Application No: A/193/20/PL
Site Address: Ham Manor Cottage Ham Manor Way Angmering BN16 4JQ
Description of works: Erection of a 1 No. 3 bedroom chalet bungalow & detached garage. This site is in CiL Zone 3 and is CIL Liable as dwelling.

Thank you for your internet representation made on 16th February 2021 which has been recorded as an objection with the comments as follows:

Proposed Street Scene (Scale 1:200)

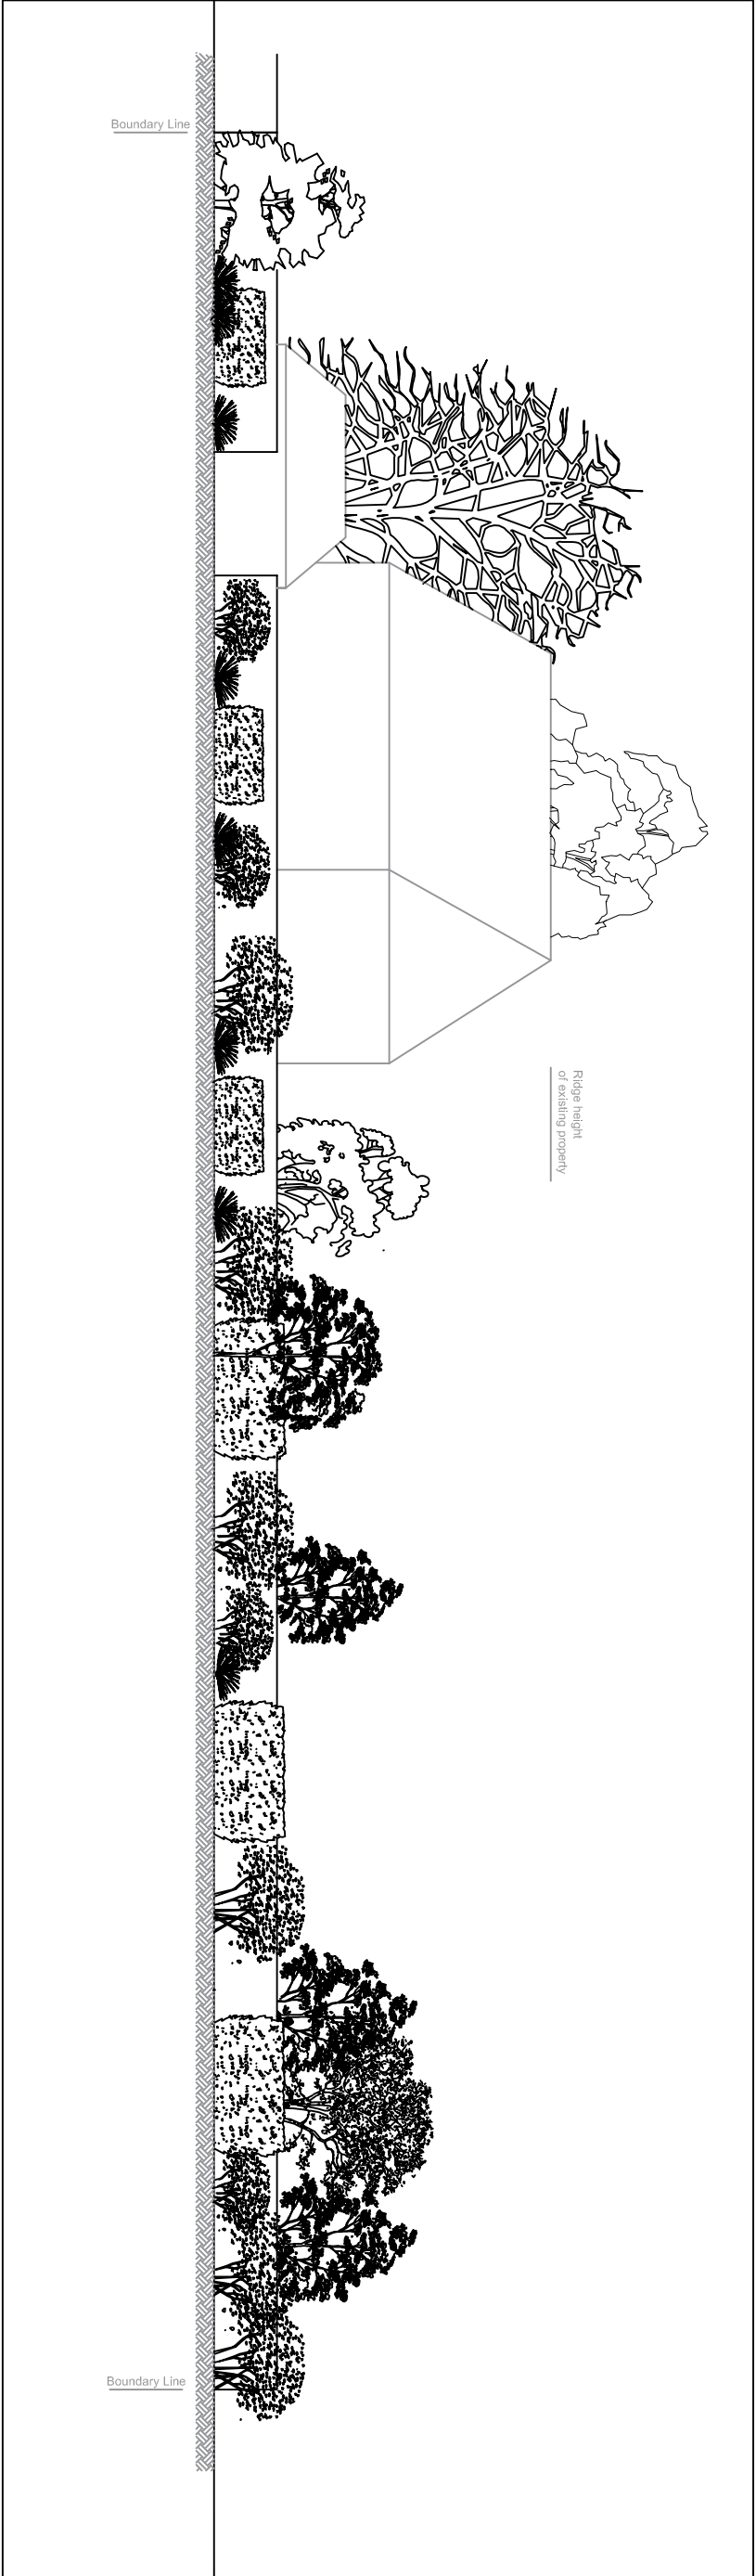
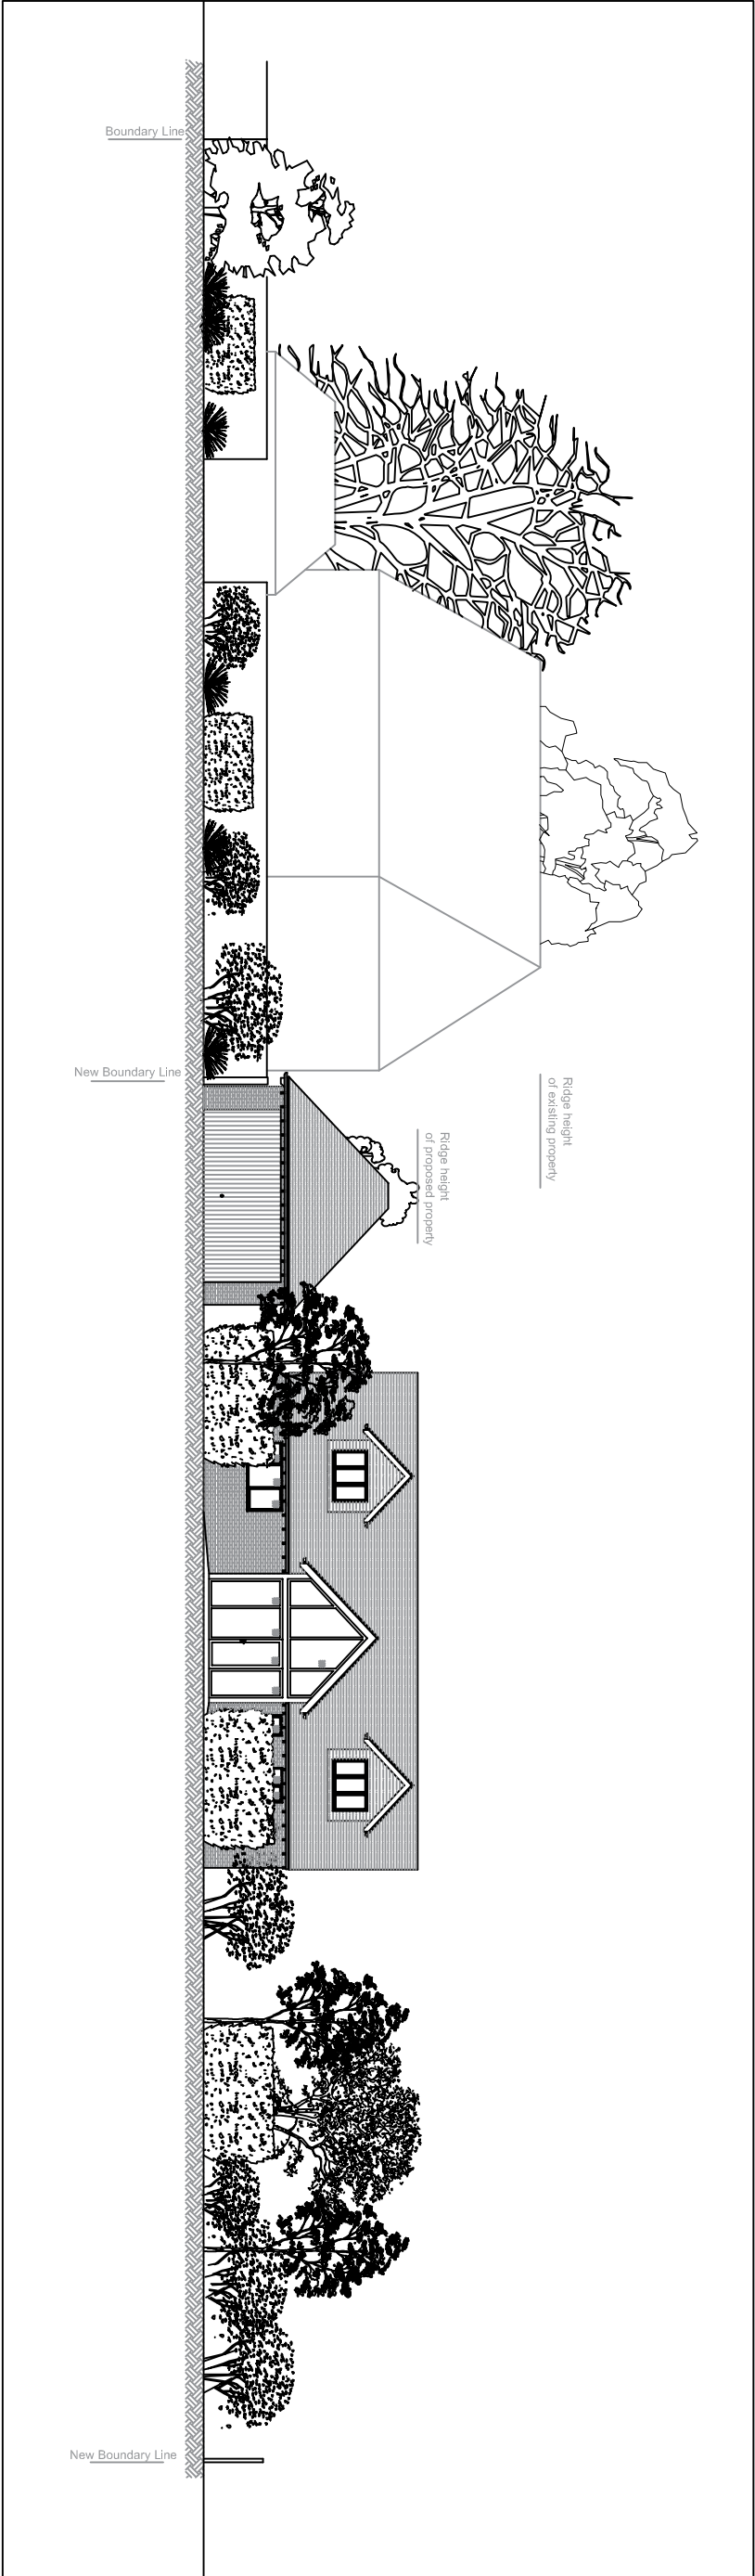
Additional dwelling will detract from the spaciousness of the estate and is not in line with the charm and character of Ham Manor; therefore against the design and compliance of policy SP1 of the local plan

The dwelling is not consistent with the building line of existing properties and therefore a breach policy SP1 of the local plan;

Revision:	A	Dec 2020	Dimension added
address	Ham Manor Cottage, Ham Manor Way, Worthing, West Sussex		
project	Proposed construction of 3 bedroom detached property with detached double garage		
title	Proposed Block Plan		
scale	date	dwg no.	revision
1:200 on A4		2020.275.02	A

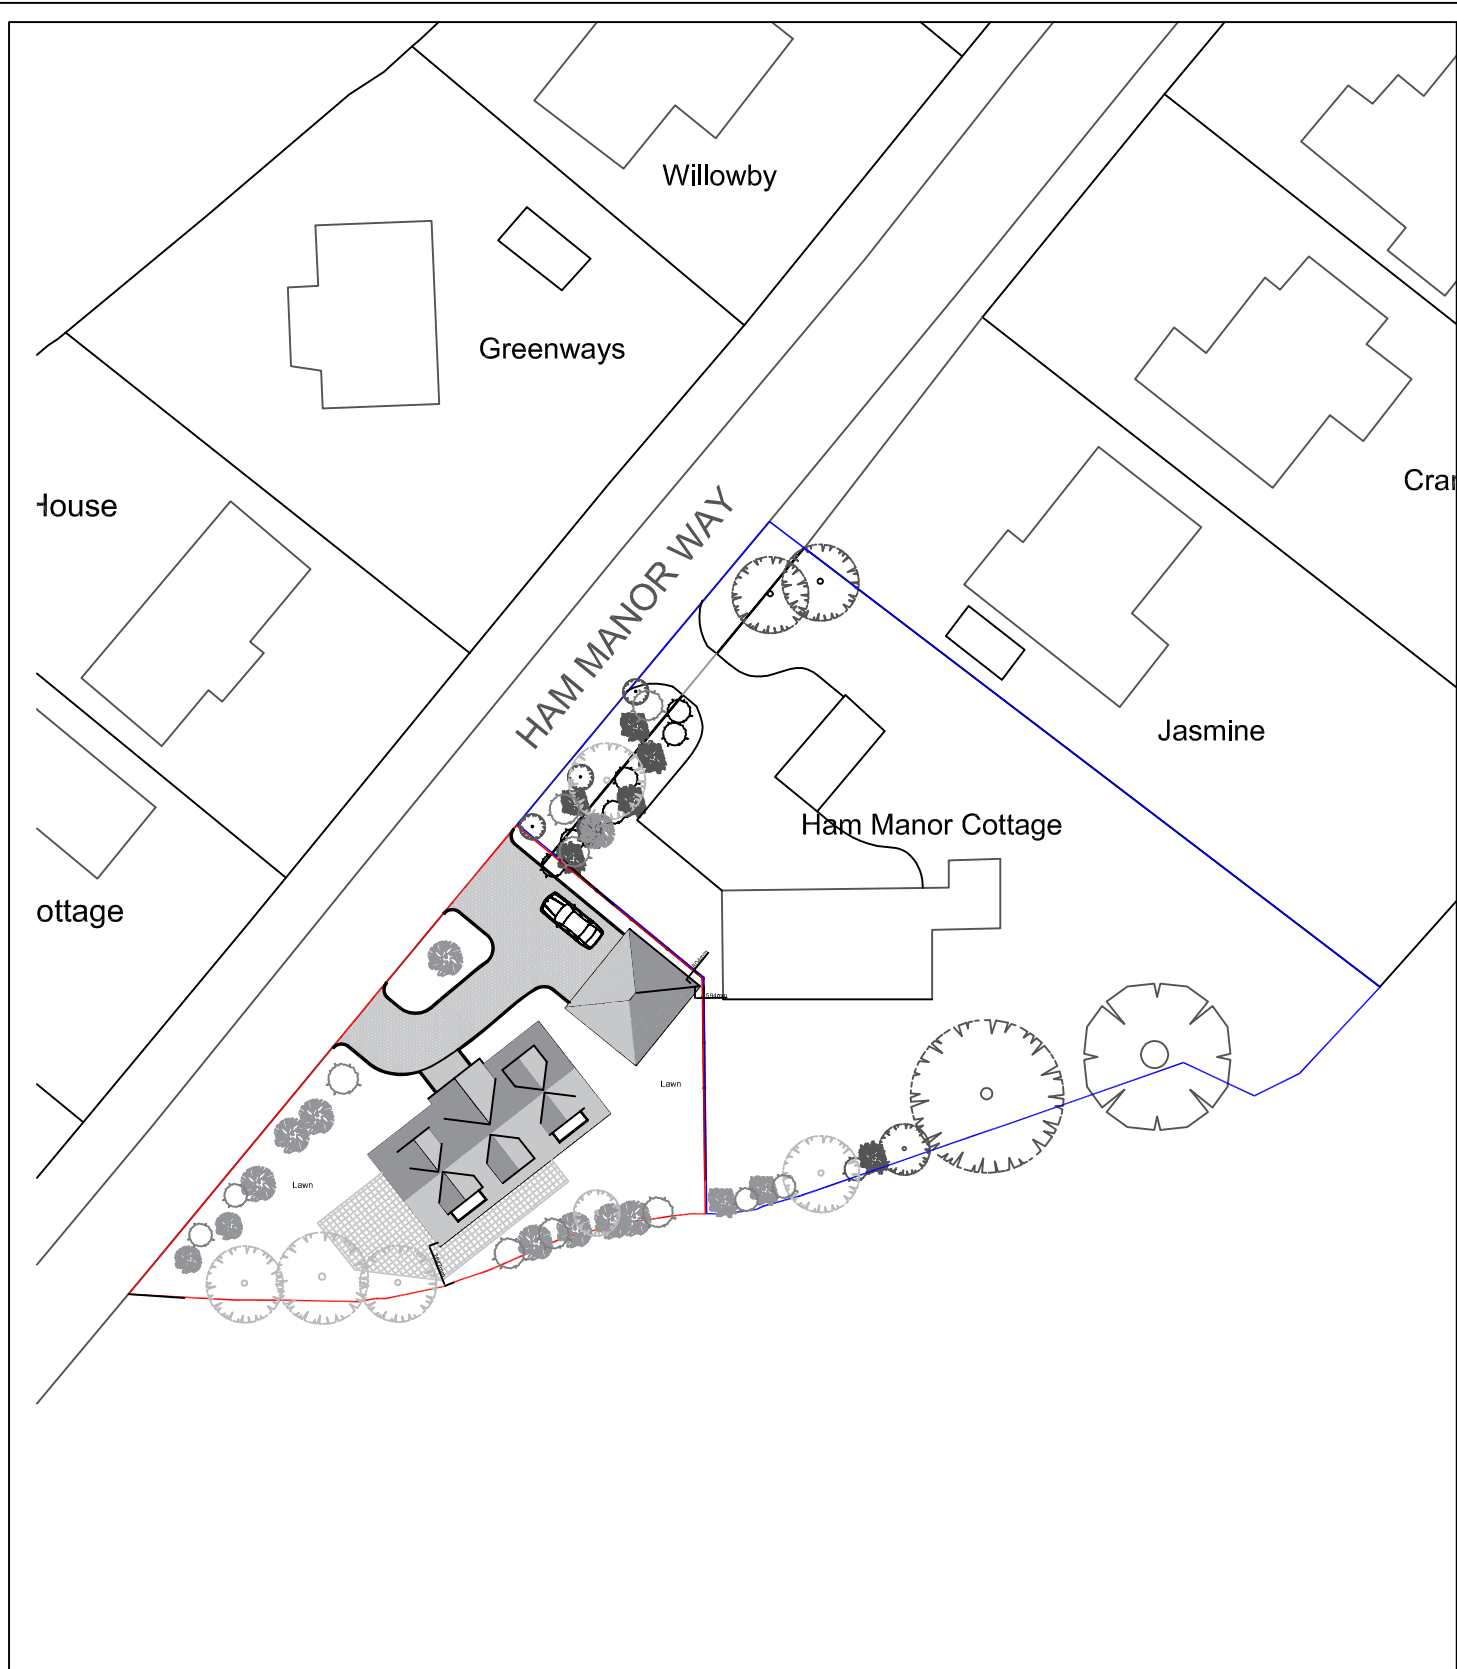
The plot is not large enough to accommodate an additional dwelling and so is in breach of the Neighbourhood plan 4.7 and 6.8; as a result shows that the property is being squeezed in which supports the point above.
